Historic England

9 July 2018

**HEYFORD PARK CAMP ROAD UPPER HEYFORD BICESTER OX25 5HD
Application No. 18/00825/HYBRID**

Thank you for your letter of 17 May 2018 regarding the above application for planning permission. On the basis of the information available to date, we offer the following advice to assist your authority in determining the application.

# HEYFORD PARK - DEMOLITION & CHANGE OF USE PLAN

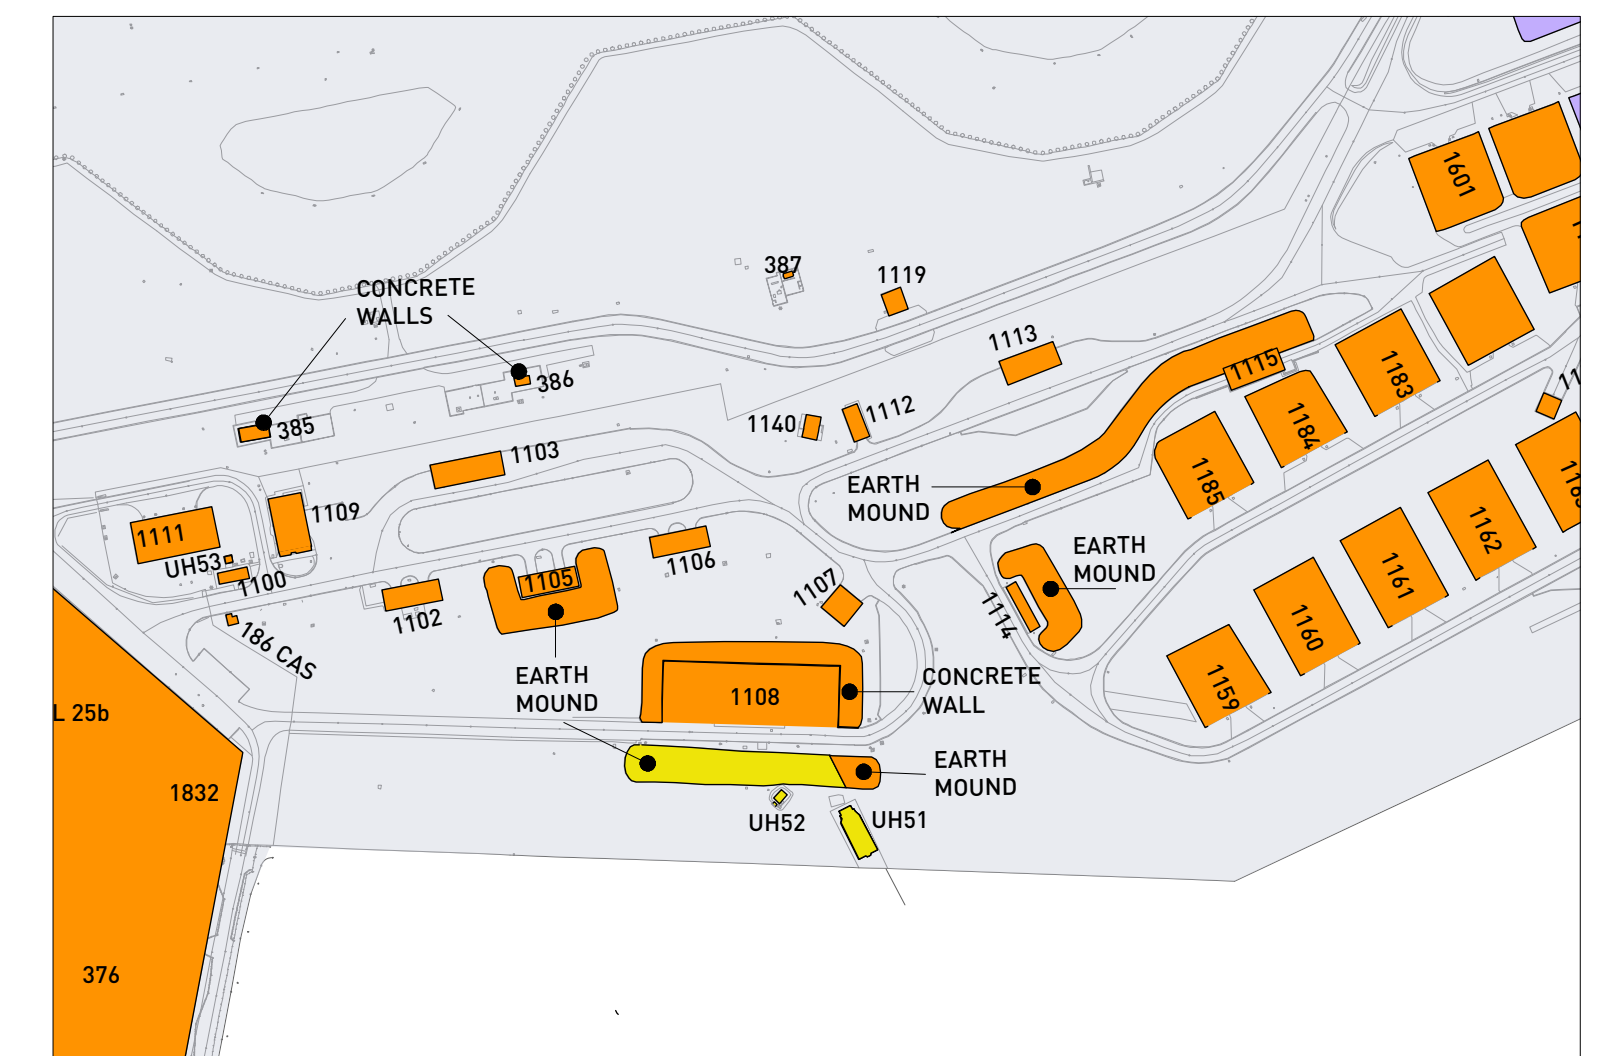
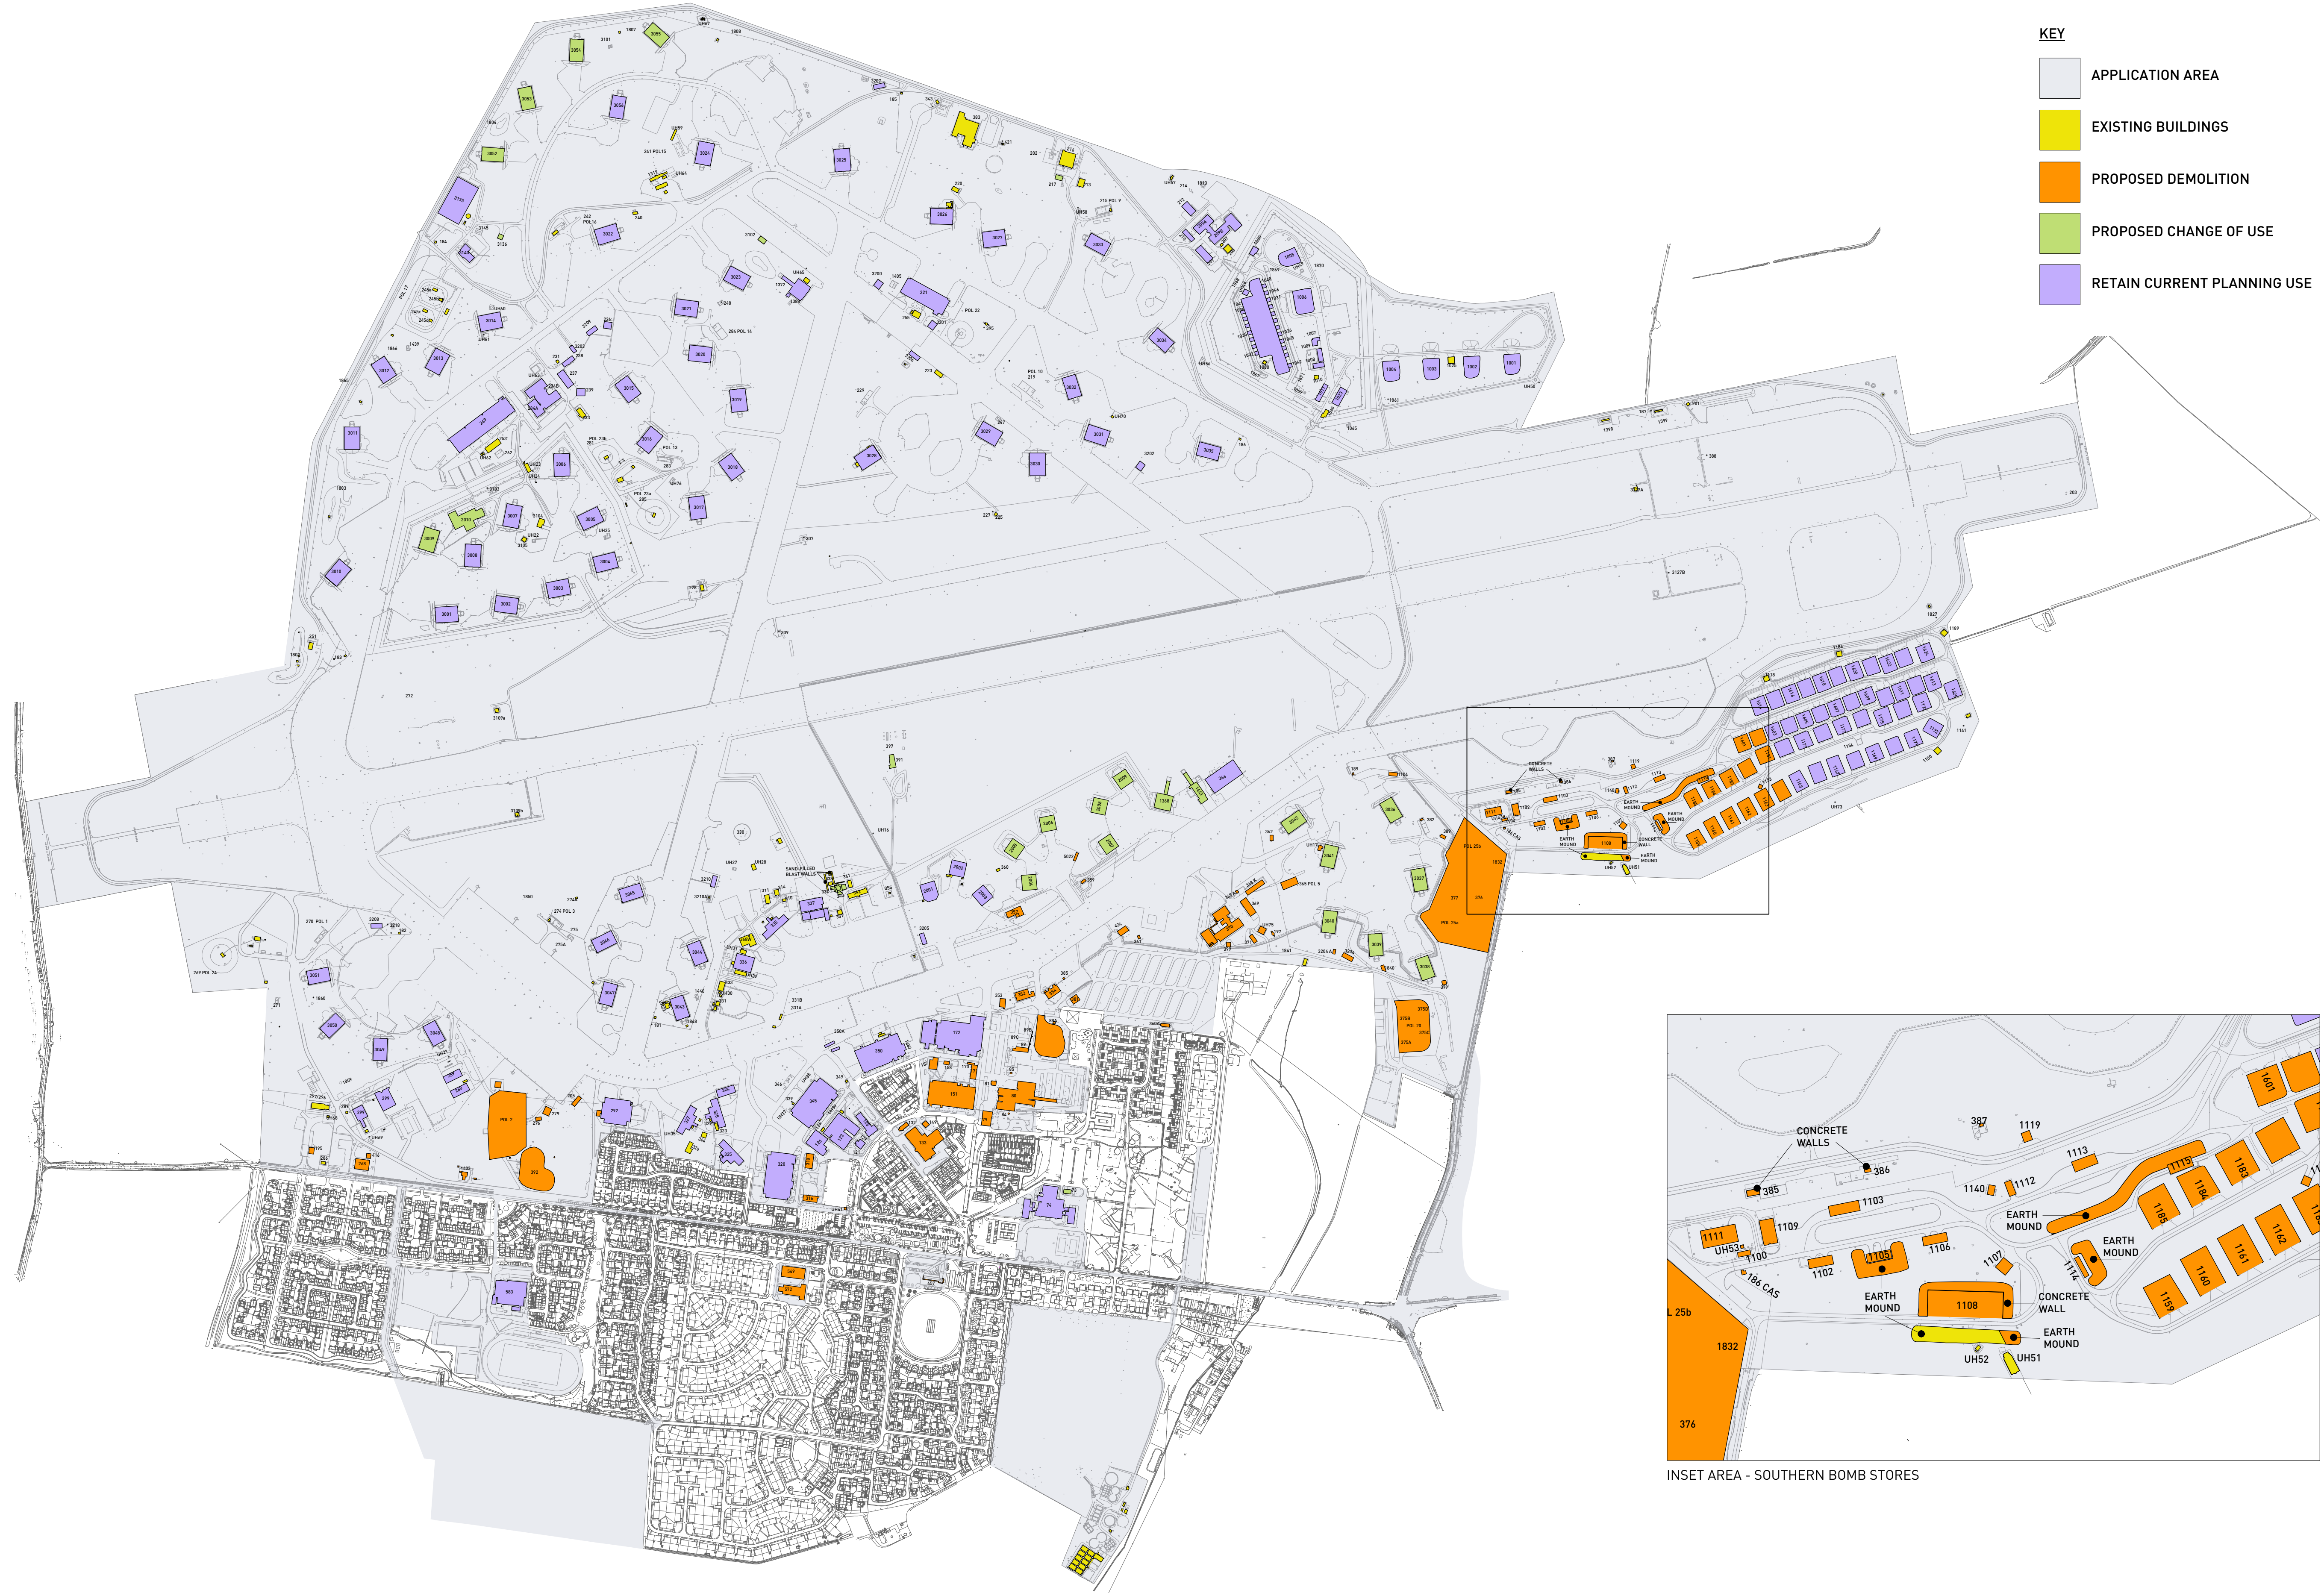
The two A-type hangars of 1925-6 identified for demolition in the Trident are highlighted as positive contributors to the conservation area in the Council's character appraisal of 2006, and are part of the largest collection of such hangars in the country. They contribute to the sense of scale and planned character of the former RAF base. The harm associated with their replacement with mixed-used development and an extra care facility does not appear to be justified anywhere in the application.

If some form of housing development is to be accepted on parcel 23, we think it should seek to minimise loss of the bomb store igloos. It may be possible to do this, whilst still securing the housing numbers allocated in Policy Villages 5, by increasing densities in other parcels, for example in Phase 9 of 10/01642/OUT (current ref: 16/02446/F). We
